East Anglia ONE North and East Anglia TWO Offshore Windfarms

Applicants' Comments on Suffolk County Council's Deadline 5 Submissions

Applicant: East Anglia TWO and East Anglia ONE North Limited
Document Reference: ExA.AS-18.D6.V1
SPR Reference: EA1N_EA2-DWF-ENV-REP-IBR-001246

Date: 24th February 2021
Revision: Version 01
Author: Royal HaskoningDHV

MARLESFORD MITIGATION SCHEME (A12)
PRELIMINARY DESIGN
(SHEET 1 OF 2)

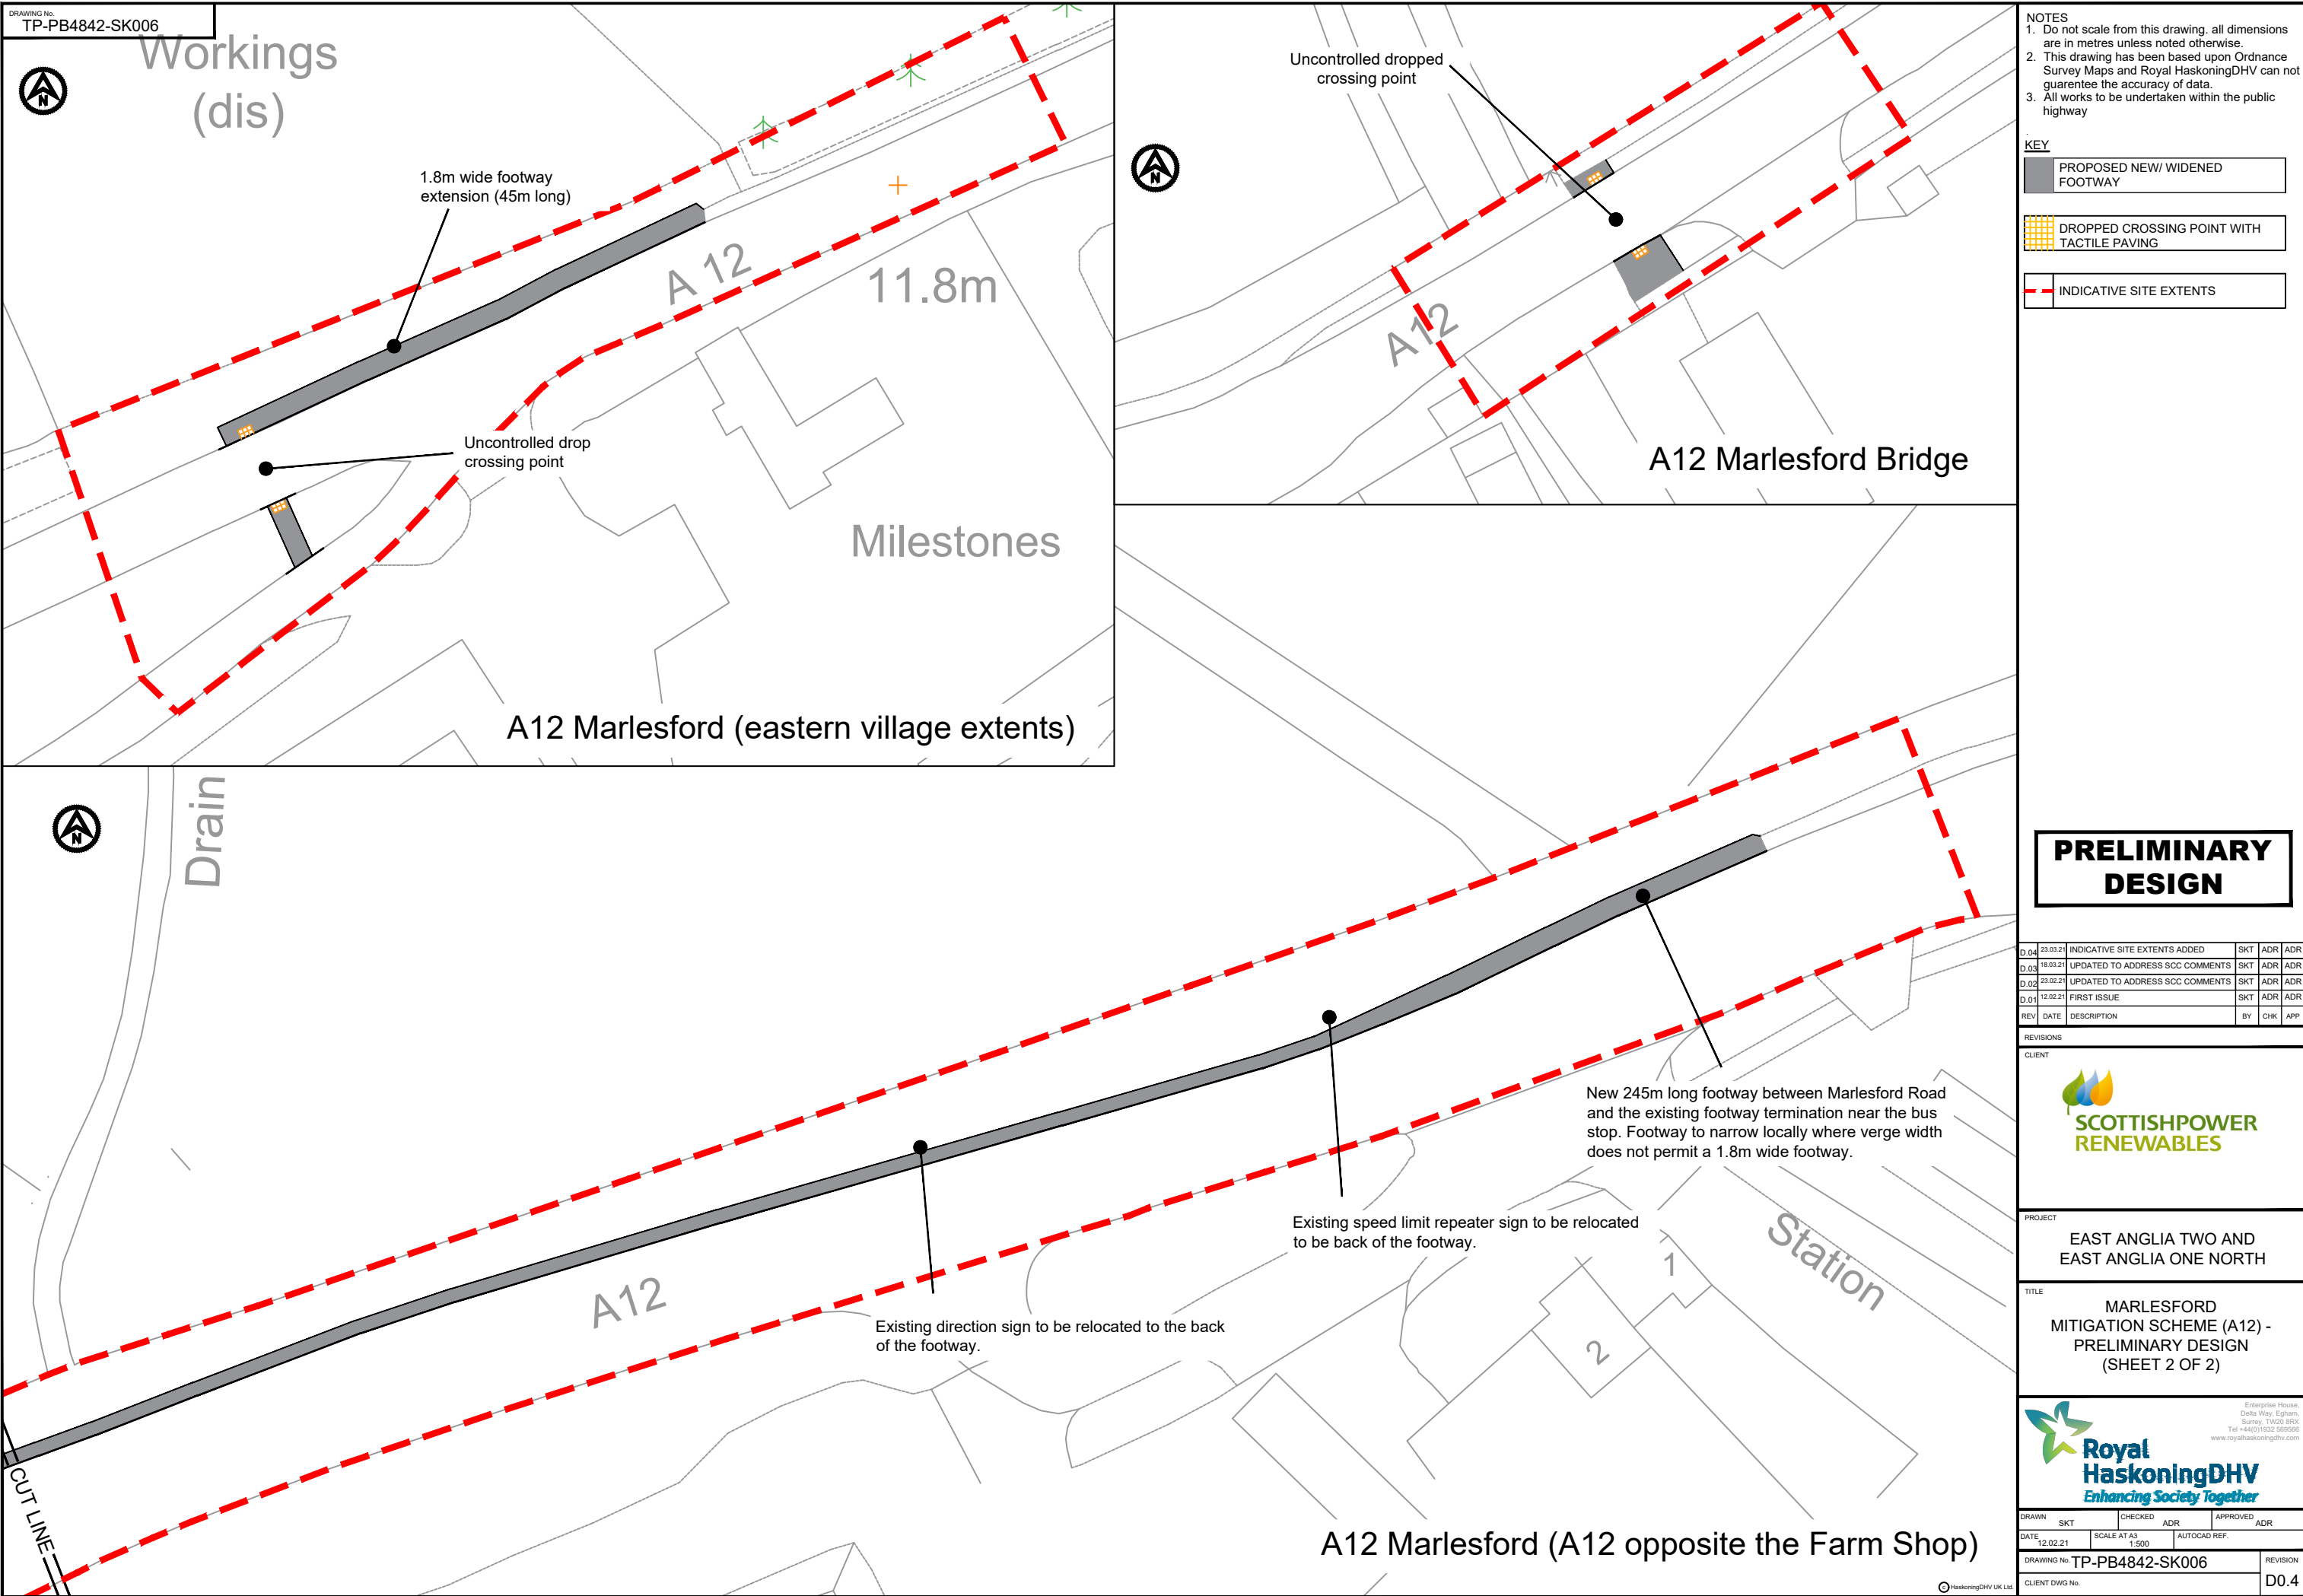
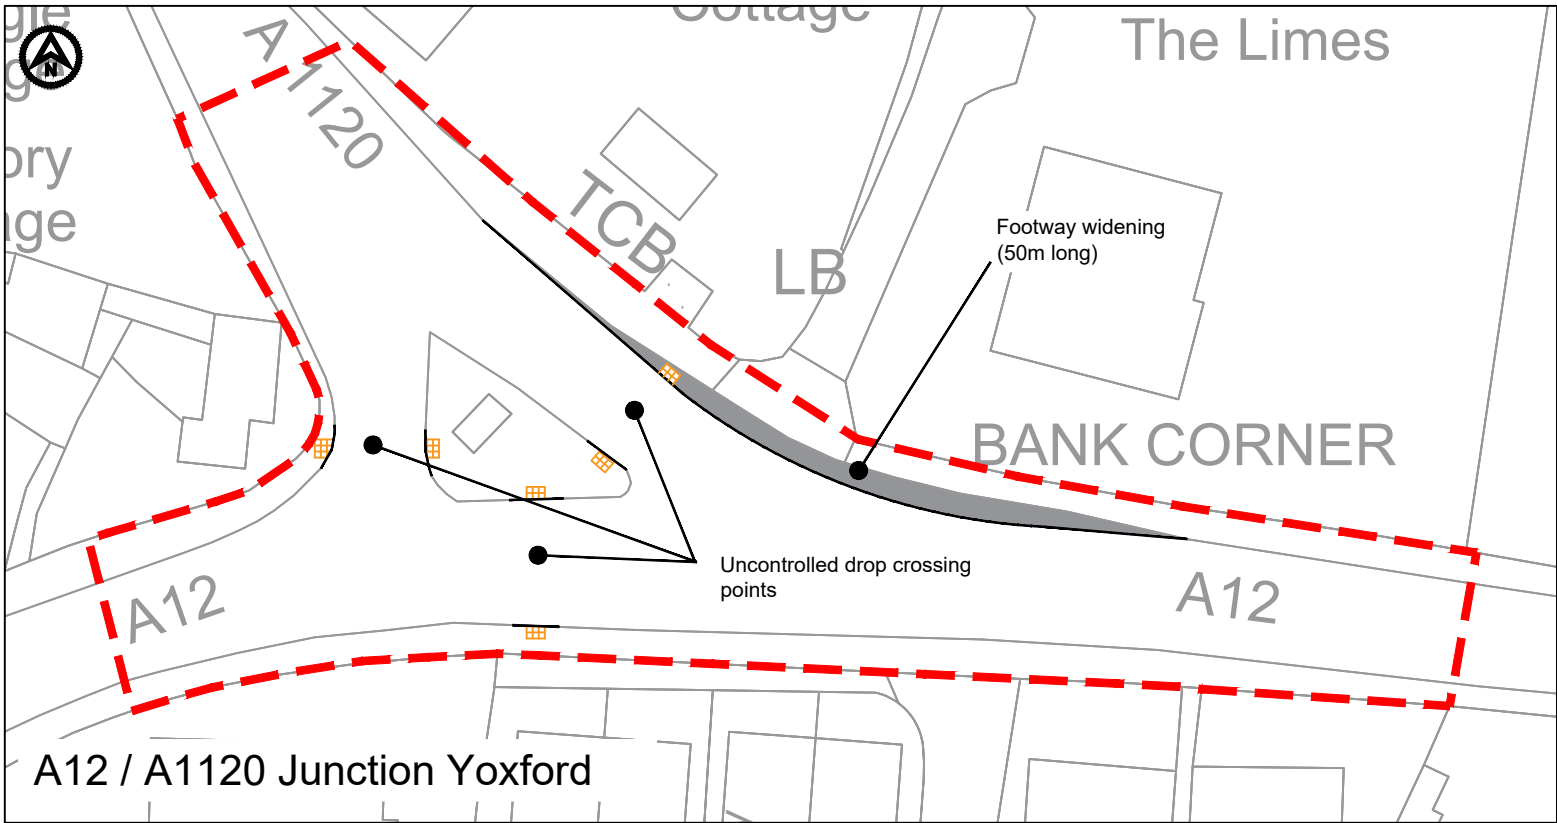
17	5.6 With regards to the Applicants' response to traffic and transport ID 7. The response fails to address SCC's concerns regarding specific impacts at the Marlesford link and the Applicants' dismissal of their impacts based on their proportional impact again which are marginally below the 30% threshold being broadly a 20% to 26% proportional increase. The Applicants' point regarding peak hour assessment for	Please see response to ID12.

ID	Written Representation	Applicants' Comments
		<p>(Marlesford and Yoxford) which are proportionate to the Projects' contribution to the cumulative impact. These improvements would not conflict with any future schemes proposed by SZC or SCC.</p> <p>For Link 3, SZC is proposing embedded mitigation in the form of Public Right of Way (PRoW) improvements and a signalised crossing. It has been agreed with SCC that this scheme will mitigate cumulative impacts with the Projects and is likely to be delivered prior to significant cumulative impacts manifesting. Therefore, there is no further mitigation required of the Projects at this location.</p> <p>An updated the Sizewell C Cumulative Impact Assessment Note (Traffic and Transport) (document reference ExA.AS-6.D6.V2) has been submitted to the examination at Deadline 6.</p>
13	<p>5.2 With regards to Written Question 4, SCC disagrees with the conclusion that a project impact that is lower than the ES threshold should be immediately dismissed given that the purpose of a cumulative impact assessment is to understand in combination impacts across relevant projects and whether these in combination impacts trigger effects. The applicant has identified that they are not rigidly applying the thresholds set out within the Guidance of Environmental Assessment of Road Traffic (GEART); however, a slightly higher impact on these links than they have calculated would result in a greater classification of impact; and therefore, would result in further consideration of their impacts. This is considered to be rigidly applying thresholds, especially given the sensitivity of the locations e.g. villages that front onto the A12. Regardless of the threshold, the Council disagrees with dismissing impacts on this basis.</p>	<p>Please see response to ID12.</p>
